Norwich to Tilbury

Document: 6.5.A1 Environmental Statement Appendix 5.1 - National
Grid's response to the EIA Scoping Opinion

Planning Inspectorate Reference: EN020027

Drawing Number:	10051663-ARC-EBD-ZZ-DR-ZZ-00009-S2	Revision:	P01
-----------------	------------------------------------	-----------	-----

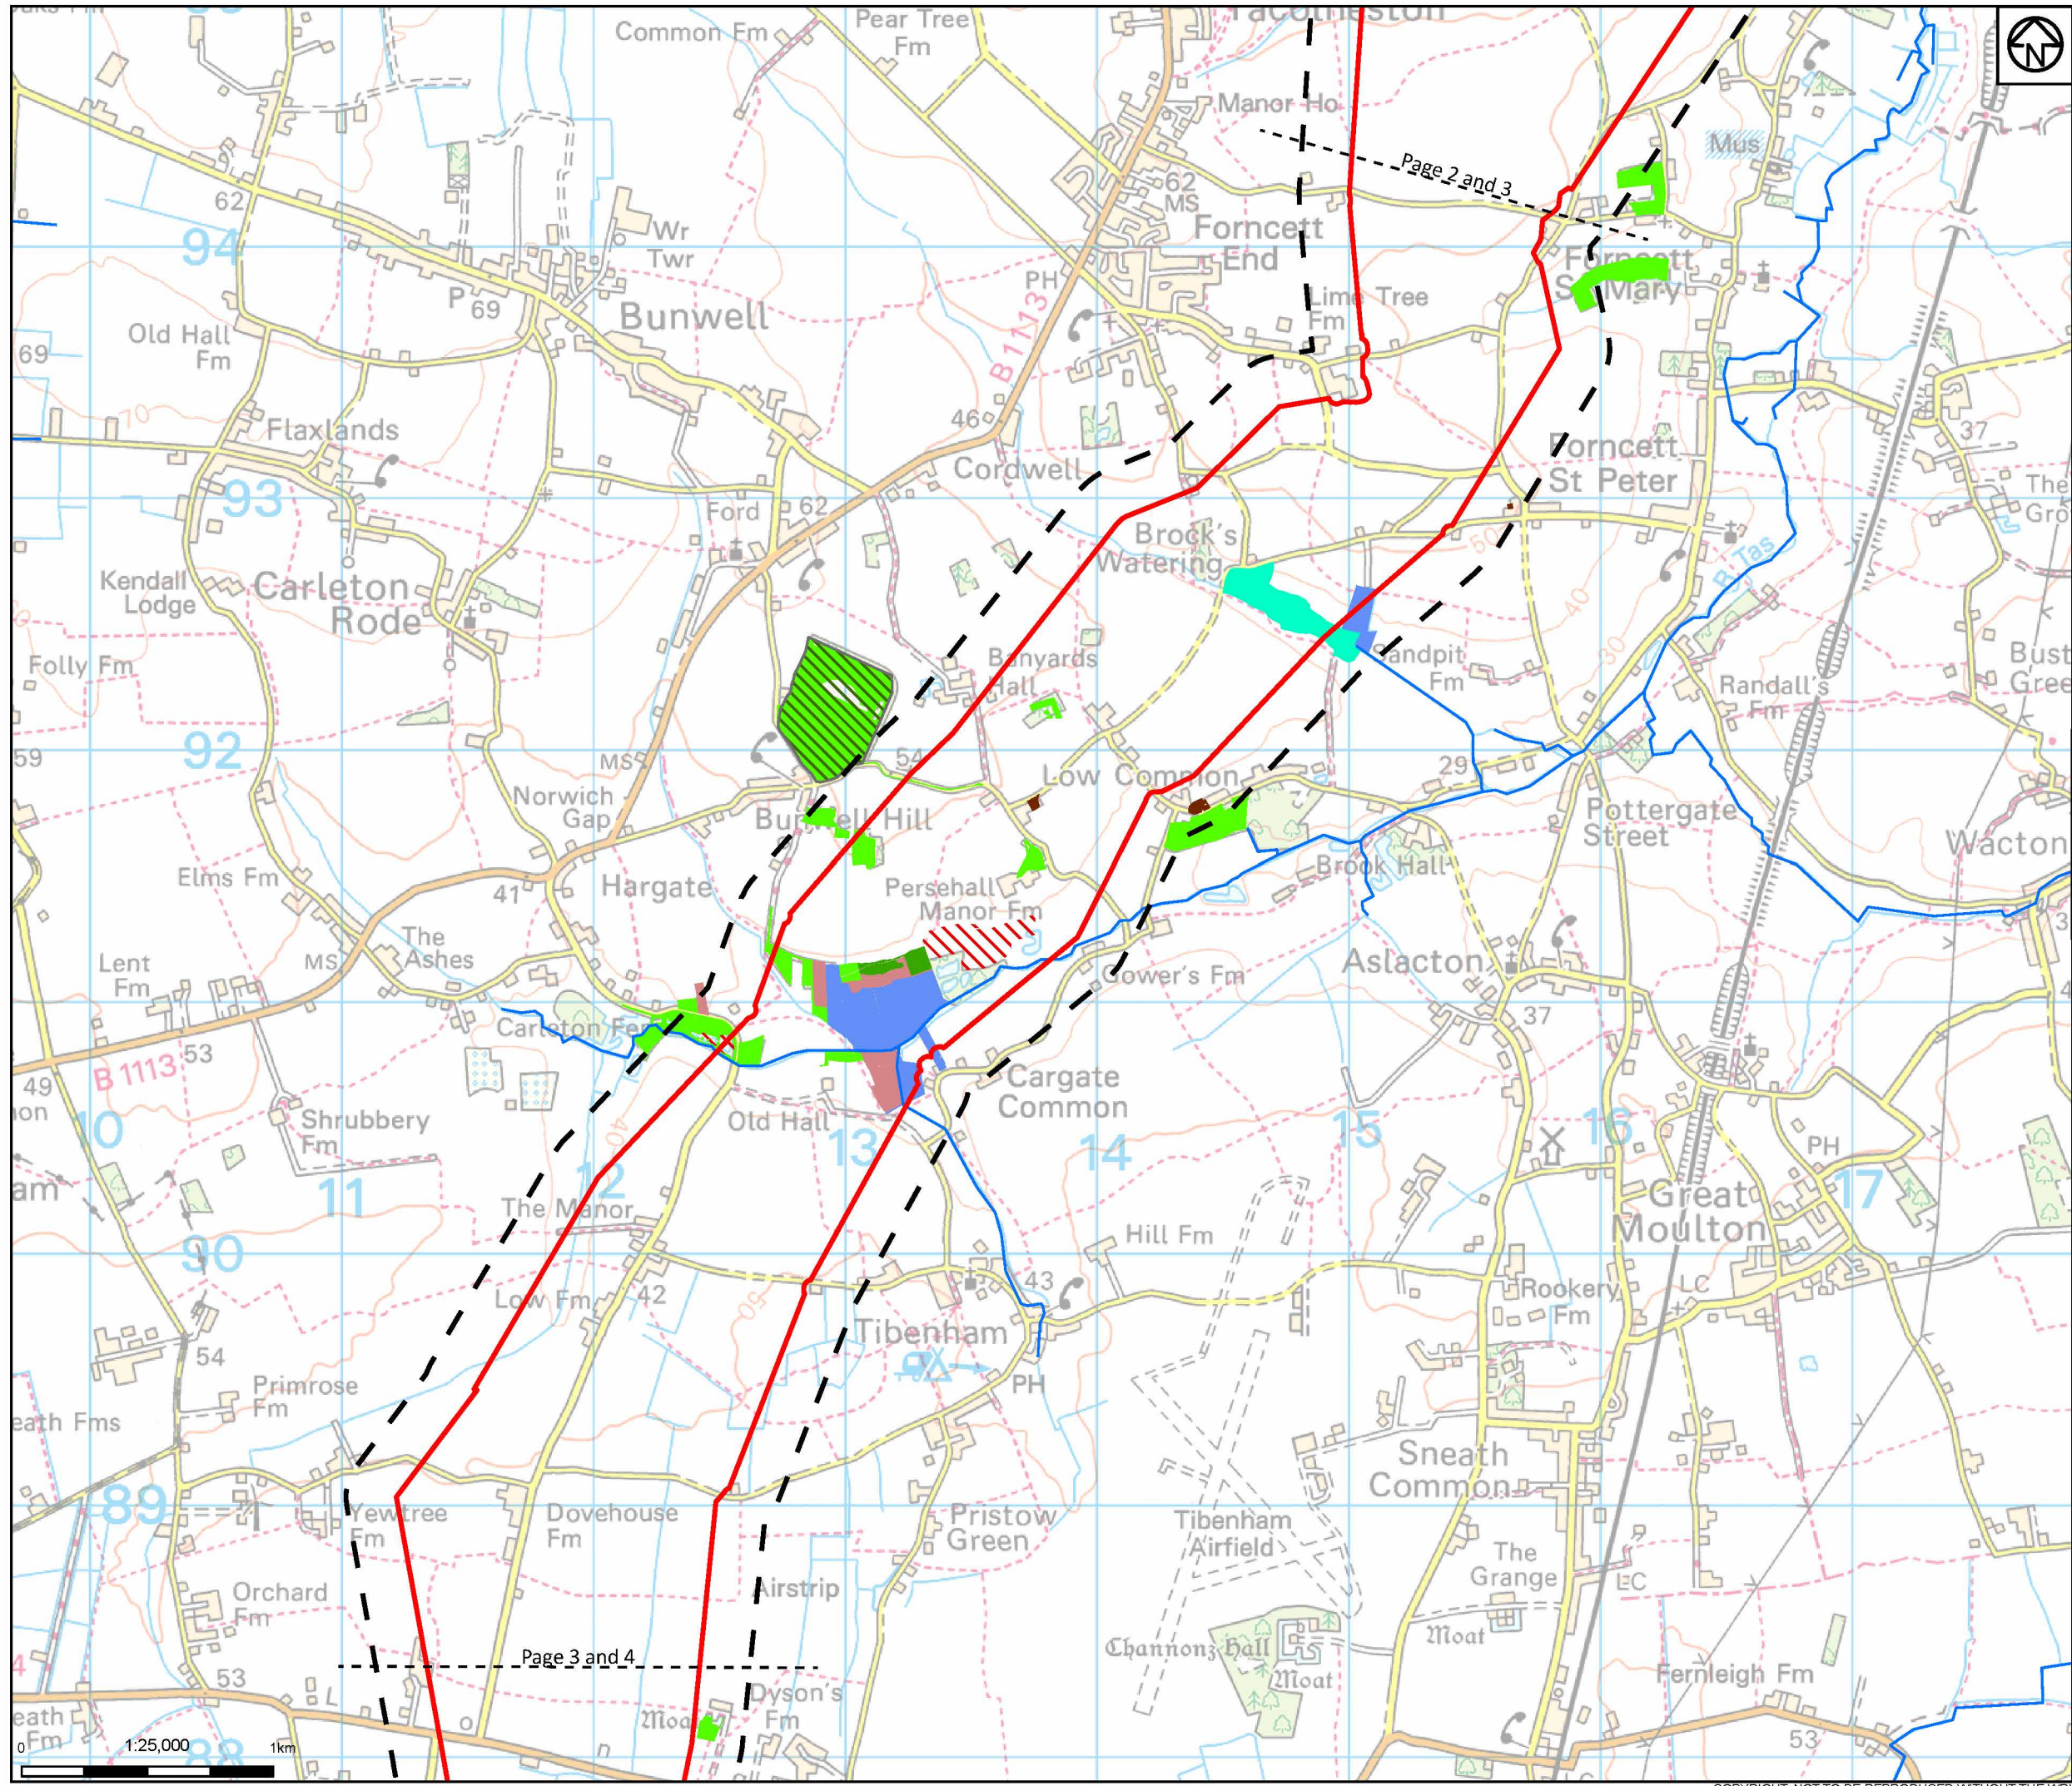
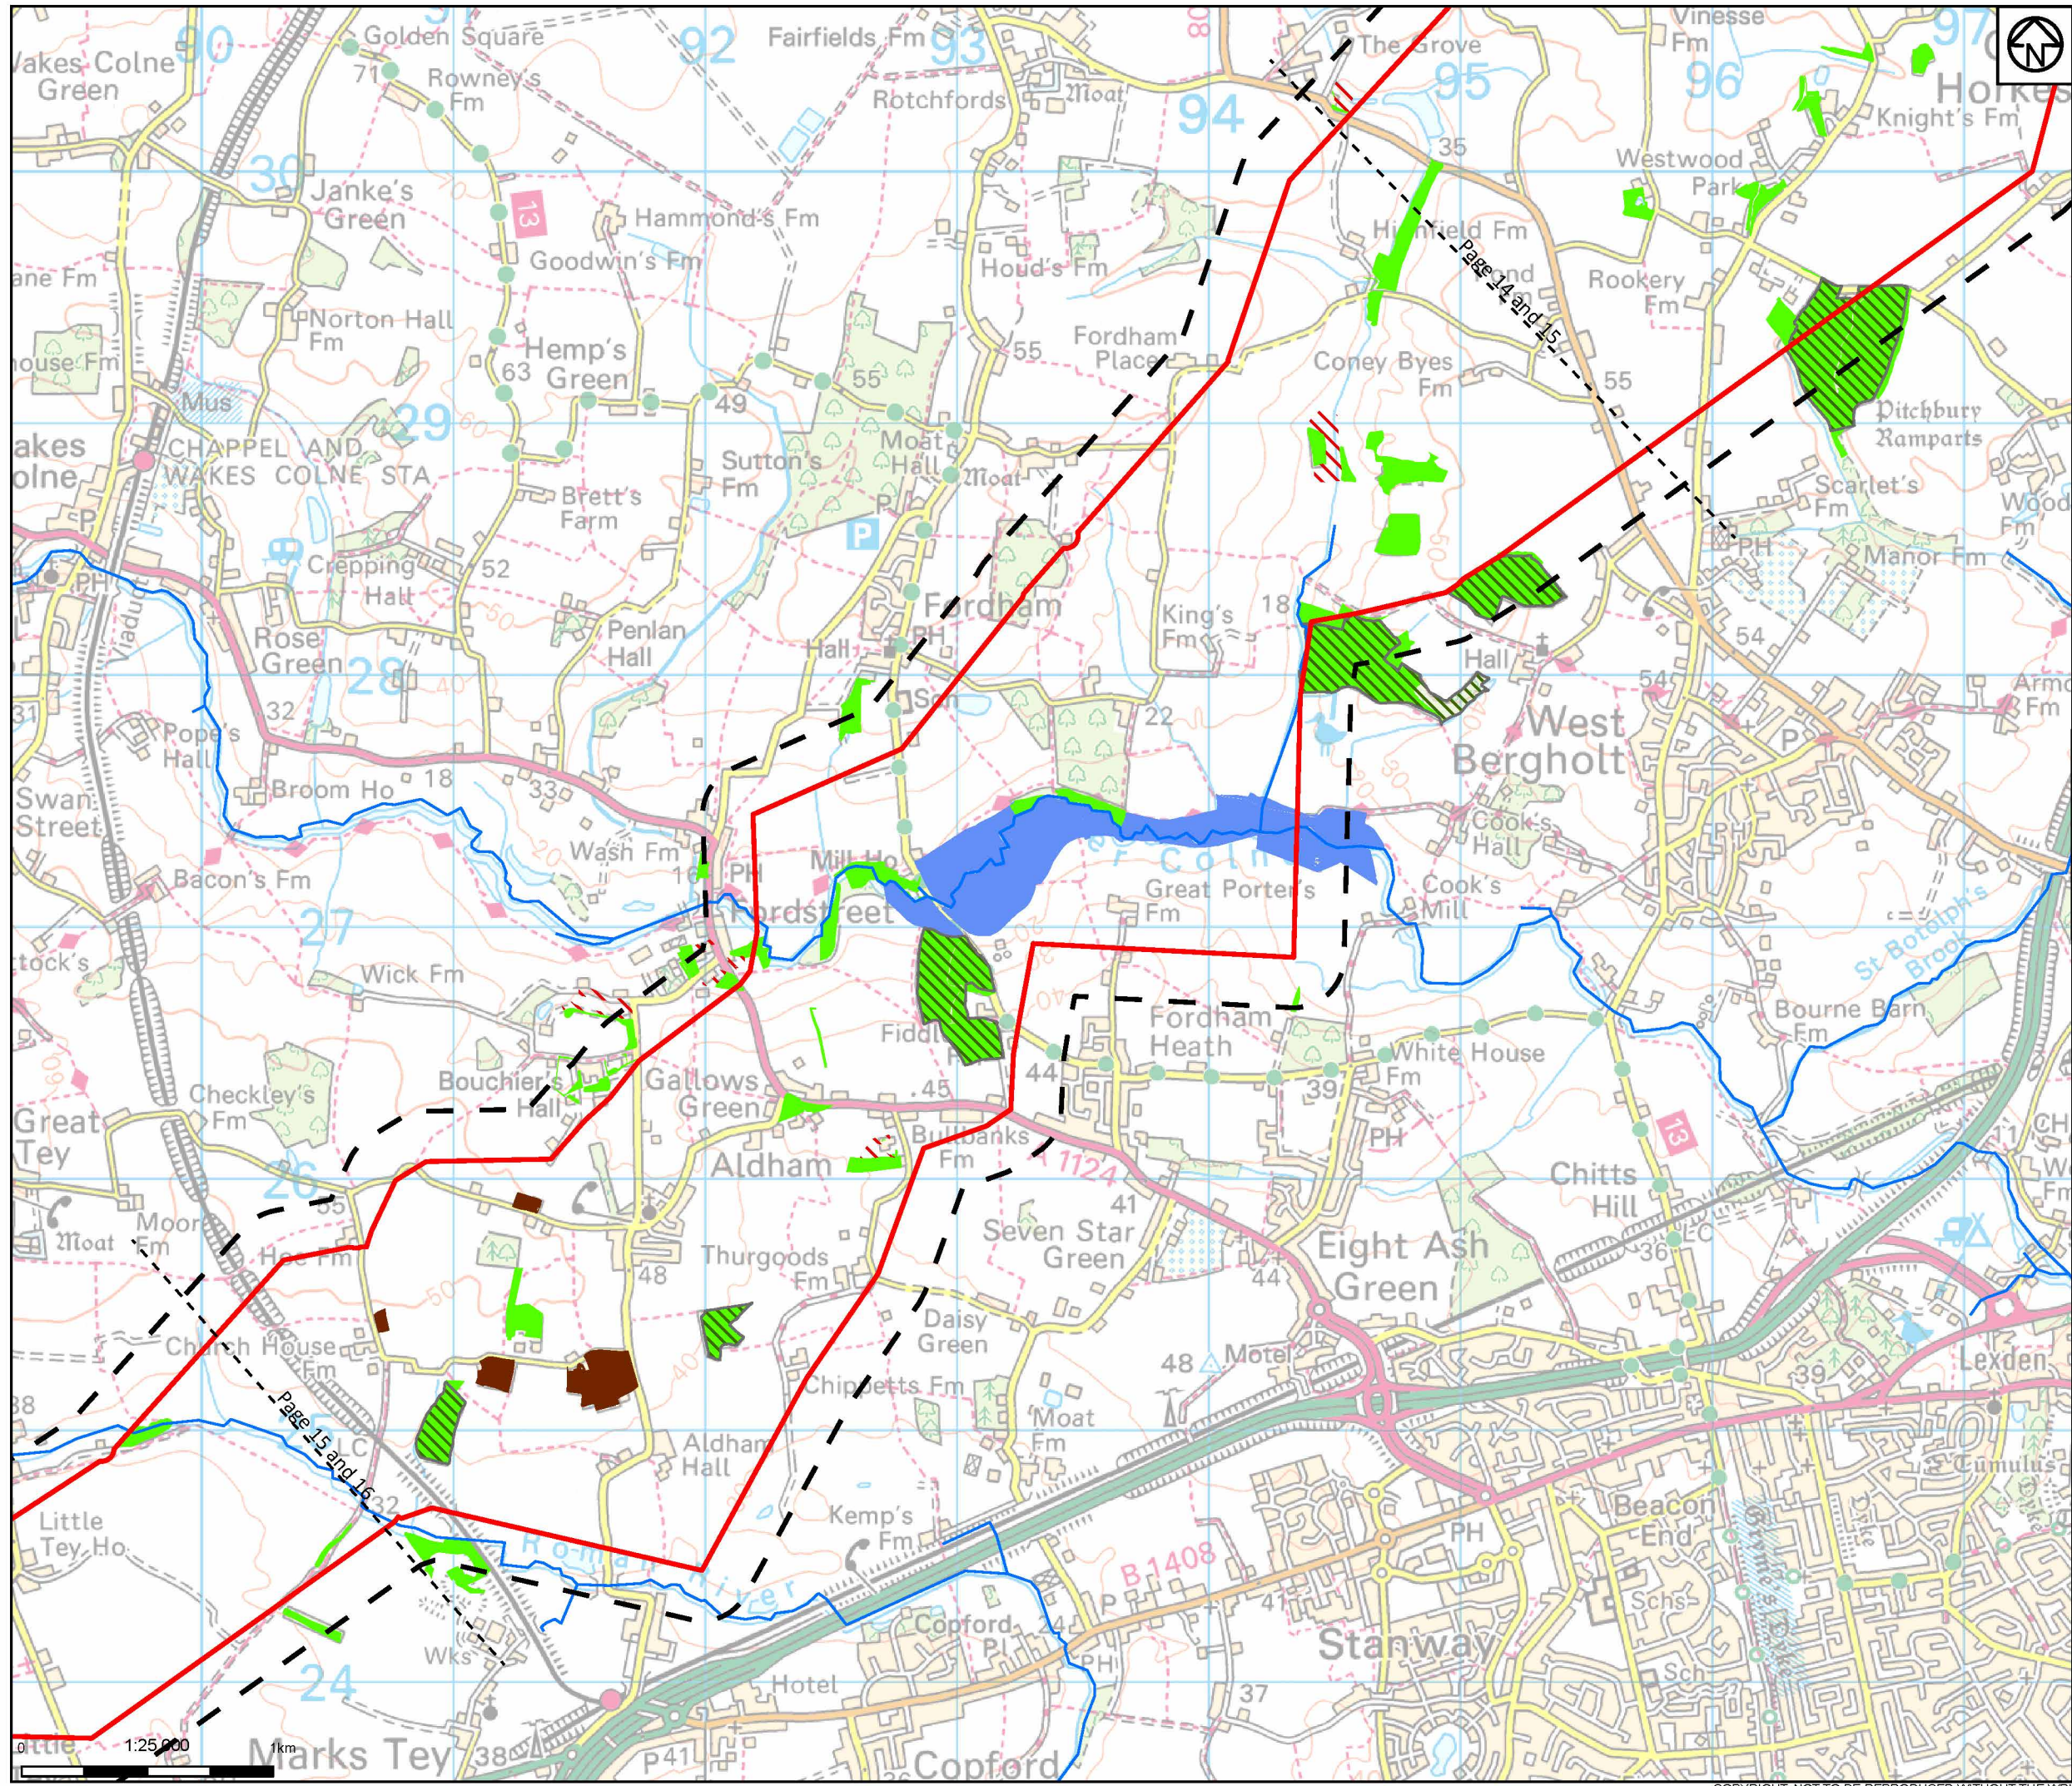
| Reference from the EIA Scoping Opinion | Aspect | Planning Inspectorate's Comment in the EIA Scoping Opinion | Project Response |
|--|--|---|--|
| Figure 8.3 | Legend | <i>The Legend to Figure 8.3 includes 'No main habitat but additional habitats present'. The ES should explain what is meant by this statement.</i> | <i>'No main habitat but additional habitats present'</i> is a specific category within the Natural England spatial dataset, that describes the geographic extent and location of Natural Environment and Rural Communities Act (2006) Section 41 habitats of principal importance. Habitat survey results are presented within Appendix 8.1: Habitat Report (document reference 6.8.A1). |
